Our Ref: 20/01164/HOU  
Your Ref: 20-007-10 Barton Grove

LOCATION: 10 Barton Grove, Portsmouth, PO3 5TY

PROPOSAL: Construction of two storey rear extension and conversion of integral garage following removal of existing conservatory **(20/01164/HOU)**

Drawing:	Location and Block Plan	Dwg No:	20-007-D-01
Scale:	as shown @ A3	Project:	Barton Grove
Date:	22/09/2020	Status:	Planning

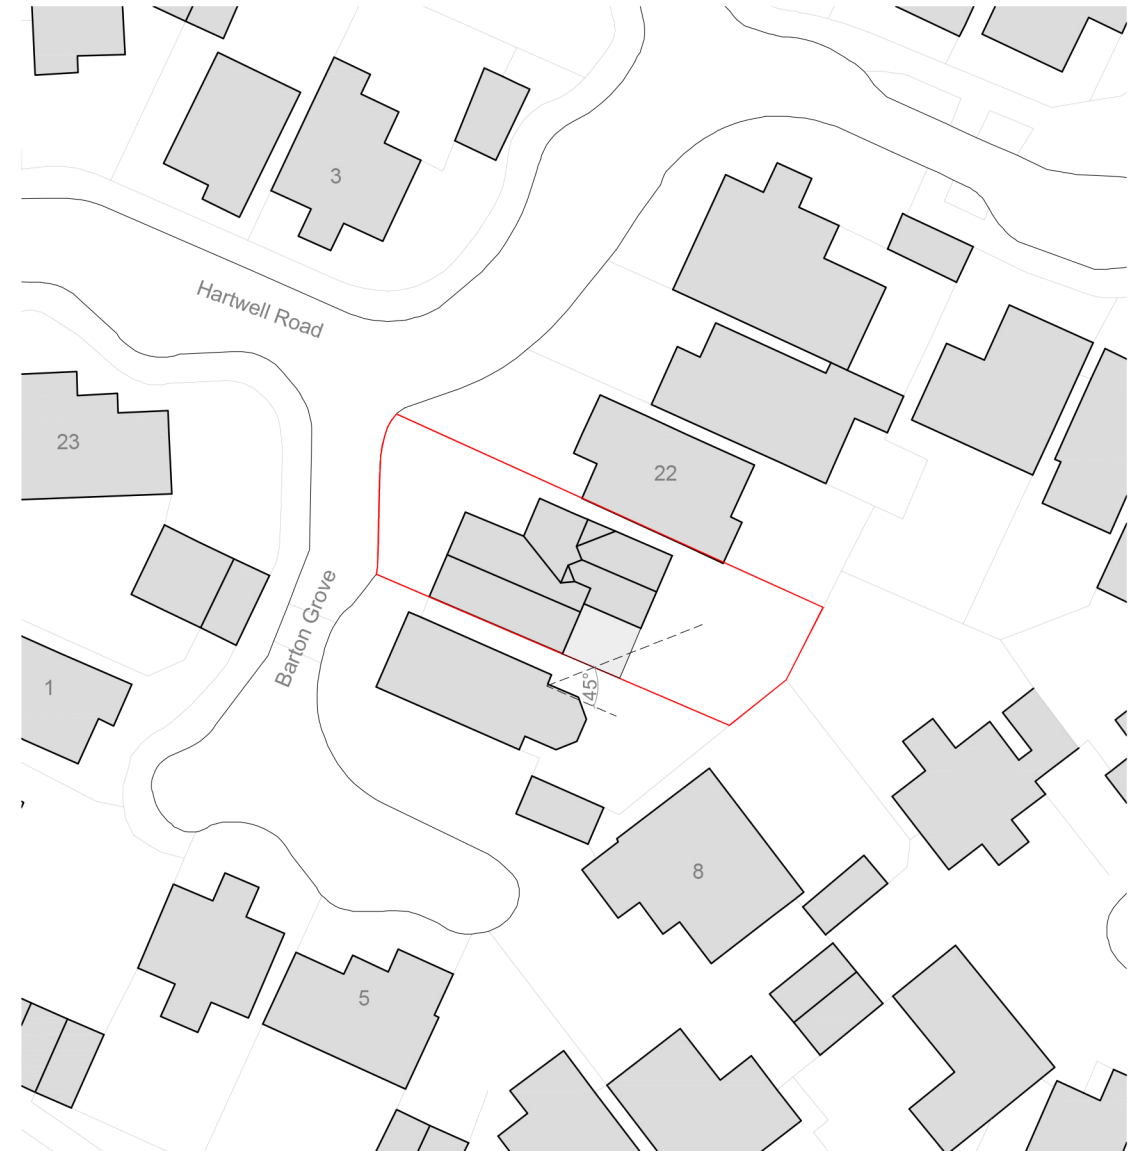
- 1) Site Location Plan D 01 does not include direction 'North'
- 2) Site layout proposed plans have not been submitted.
